City of Portland, Maine - Building or Use Permit Application
 389 Congress Street, 04101 Tel: (207) 874-8703, Fax: (207) 874-8716

Permit No: 08-1007	Issue Date:	CBL: 181 F004001
------------------------------	--------------------	----------------------------

Location of Construction: 83 COLUMBIA RD	Owner Name: WALSH DIANE F	Owner Address: 83 COLUMBIA RD	Phone:
Business Name:	Contractor Name: Keith Gautreau	Contractor Address: 85 Columbia Road Portland	Phone 2076710781
Lessee/Buyer's Name	Phone:	Permit Type: Additions - Dwellings	Zone:

Past Use: Single Family Home	Proposed Use: Single Family Home - refurbish front porch within existing footprint (after the fact) - remove rear deck & build New 18'x21' CarPort attached to the rear of the house.	Permit Fee: \$260.00	Cost of Work: \$14,000.00	CEO District: 3
Proposed Project Description: refurbish front porch within existing footprint (after the fact) - remove rear deck & build New 18'x21' CarPort attached to the rear of the house.		FIRE DEPT: <input type="checkbox"/> Approved <input type="checkbox"/> Denied	INSPECTION: Use Group: Type	
		Signature:	Signature:	
PEDESTRIAN ACTIVITIES DISTRICT (P.A.D.)				
Action <input type="checkbox"

FRONT PORCH

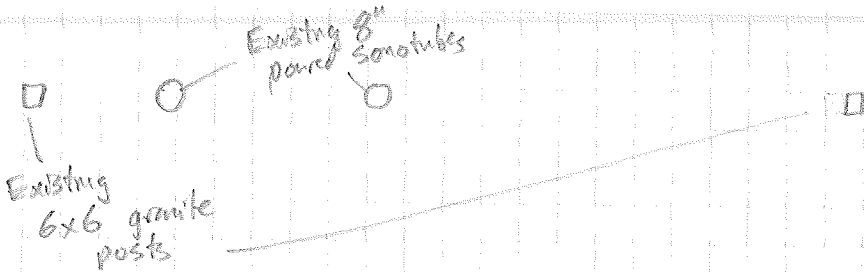
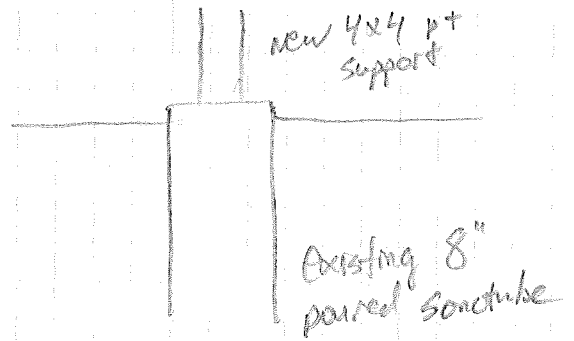
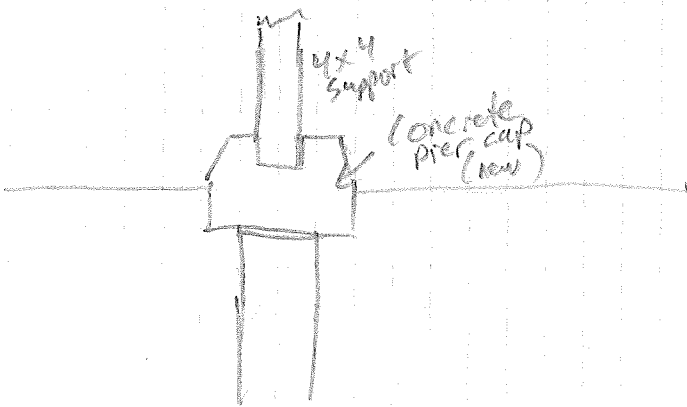
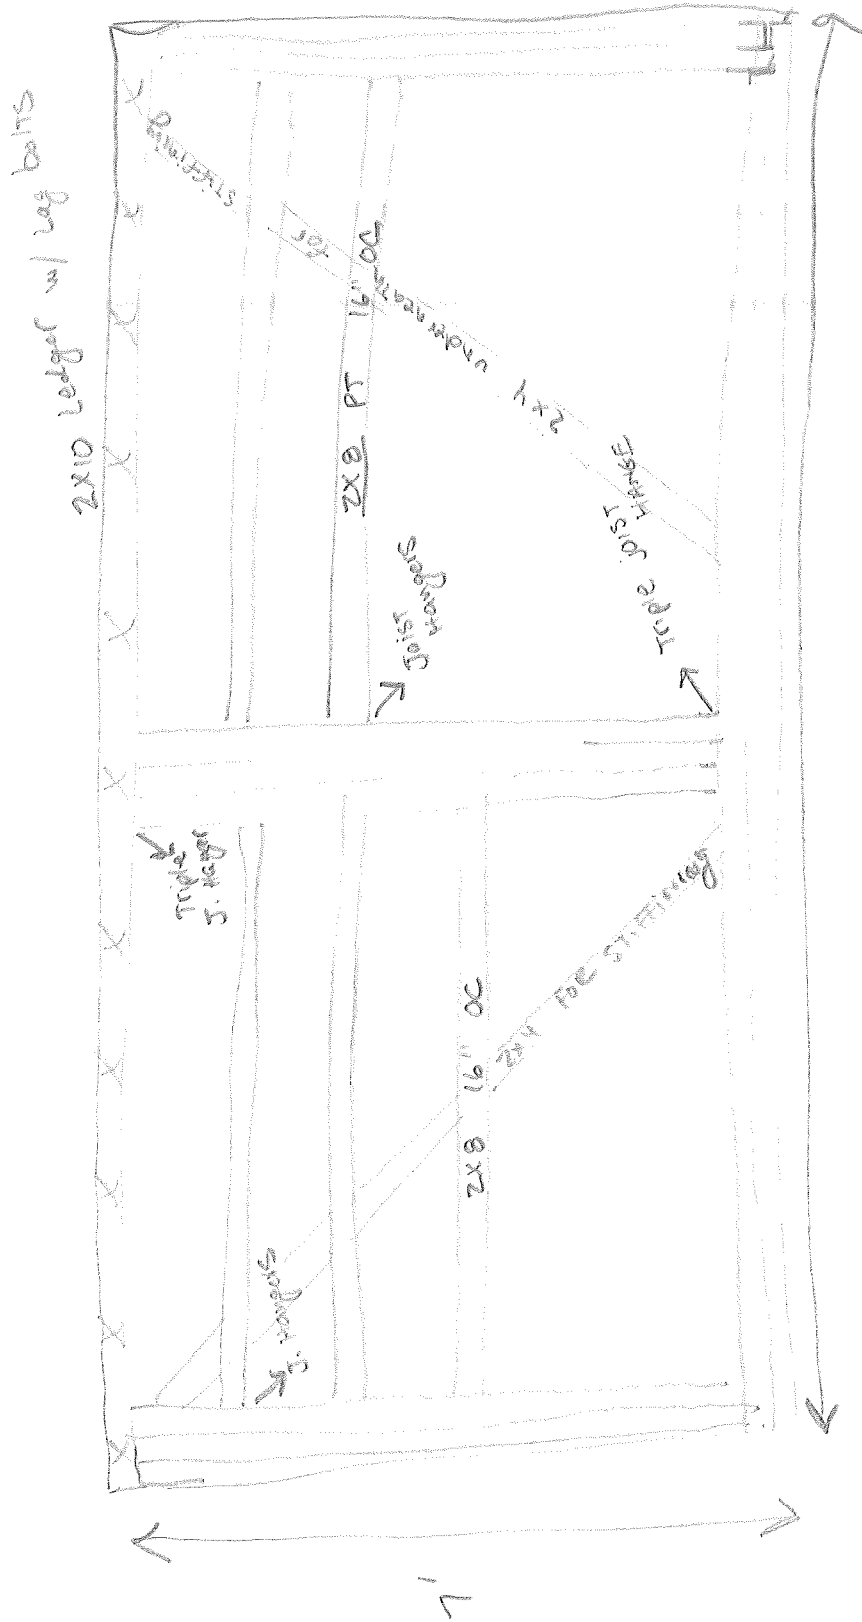
Note: Need info on 1/2 wall in portico CSH			Ok to Issue: <input checked="" type="checkbox"/>
1) Permit approved based on the plans submitted and reviewed w/owner/contractor, with additional information as agreed on and as noted on plans. 2) Frost protection must be installed per the enclosed detail as discussed w/owner/contractor. 3) Separate permits are required for any electrical, plumbing, or HVAC systems. Separate plans may need to be submitted for approval as a part of this process.
